Date: 03-Sep-2025
Our Ref: 2025/91906

**TOWN AND COUNTRY PLANNING ACT 1990
TOWN AND COUNTRY PLANNING (GENERAL PERMITTED DEVELOPMENT)
(ENGLAND) ORDER 2015 (as amended) – SCHEDULE 2, PART 1, CLASS AA
AT: 35, Moor Park Avenue, Beaumont Park, Huddersfield, HD4 7AL
Prior approval for enlargement of dwellinghouse by erection of additional storey**

Prior approval for enlargement of dwellinghouse by erection of additional storey

TITLE: FIRST FLOOR EXT'N & SINGLE STOREY REAR EXTENSION  
PROPOSED FLOOR PLANS & ELEVATIONS

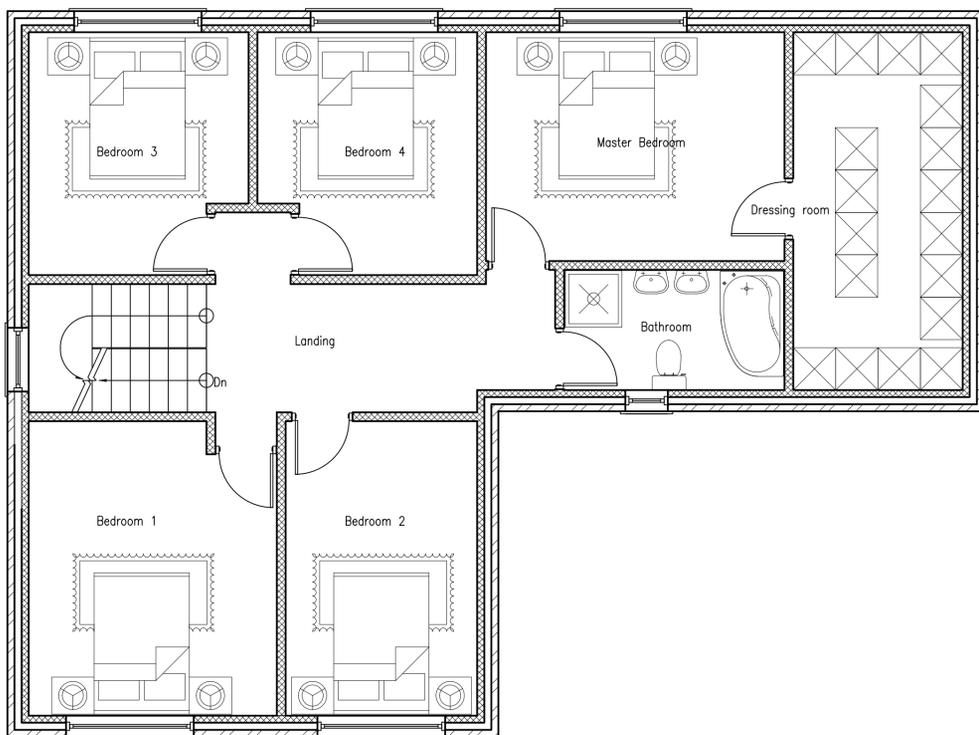
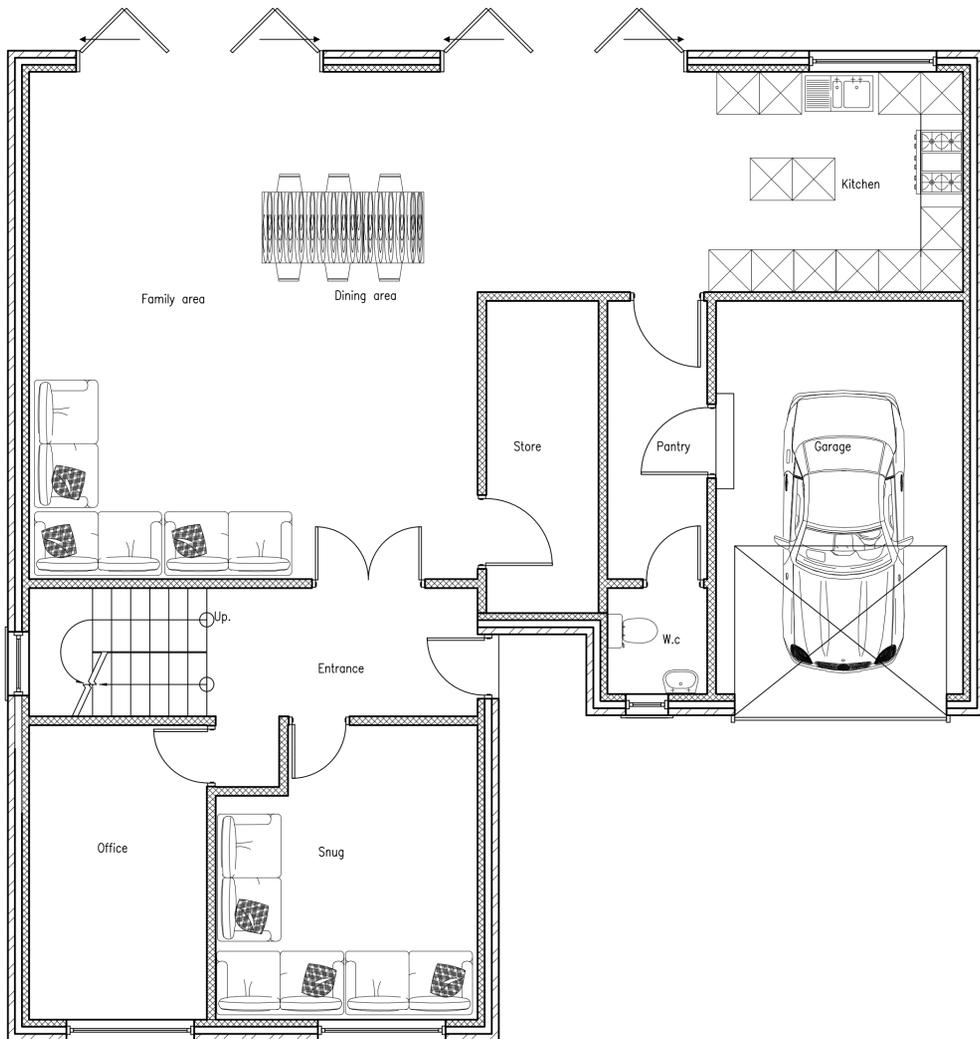
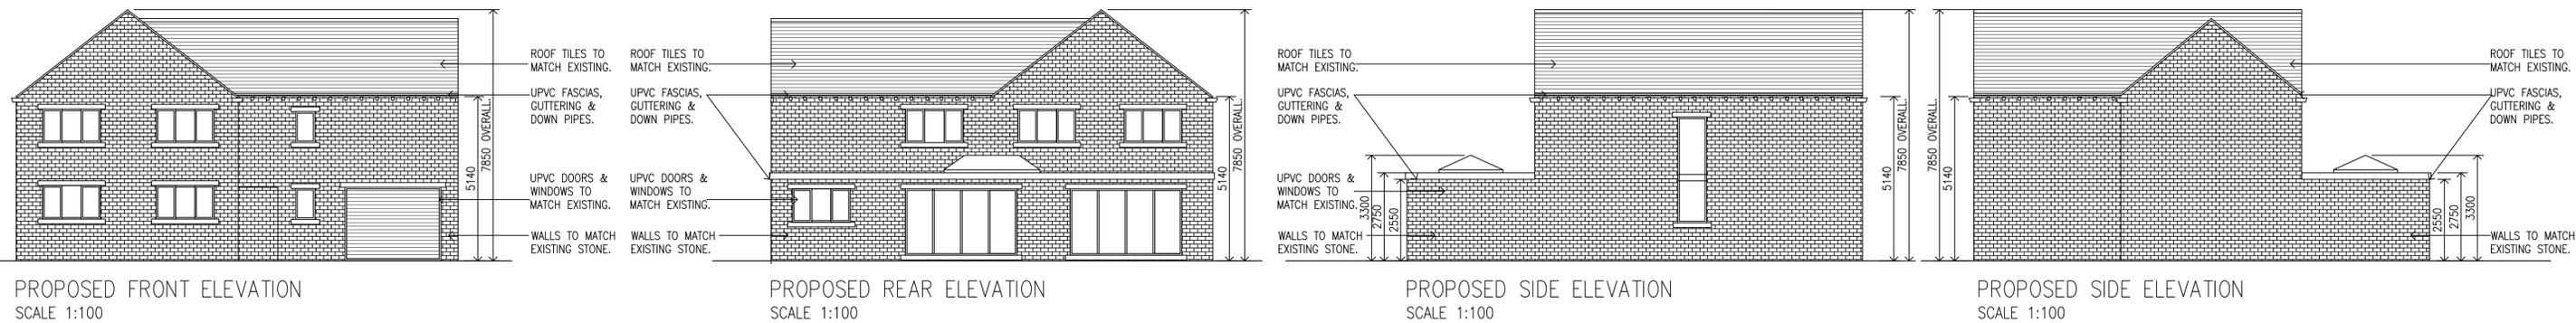
In conclusion it is considered that the proposed additional storey would be overly dominant and harmful to the proportions, appearance and design of the original dwelling as well as neighbouring properties and the wider street scene. This would be contrary to the fundamental core aims of good design set out in Chapter 12 of the NPPF, Policy LP24 of the Kirklees Local Plan and Key Design Principles 1 and 2 of the House Extensions and Alterations SPD.
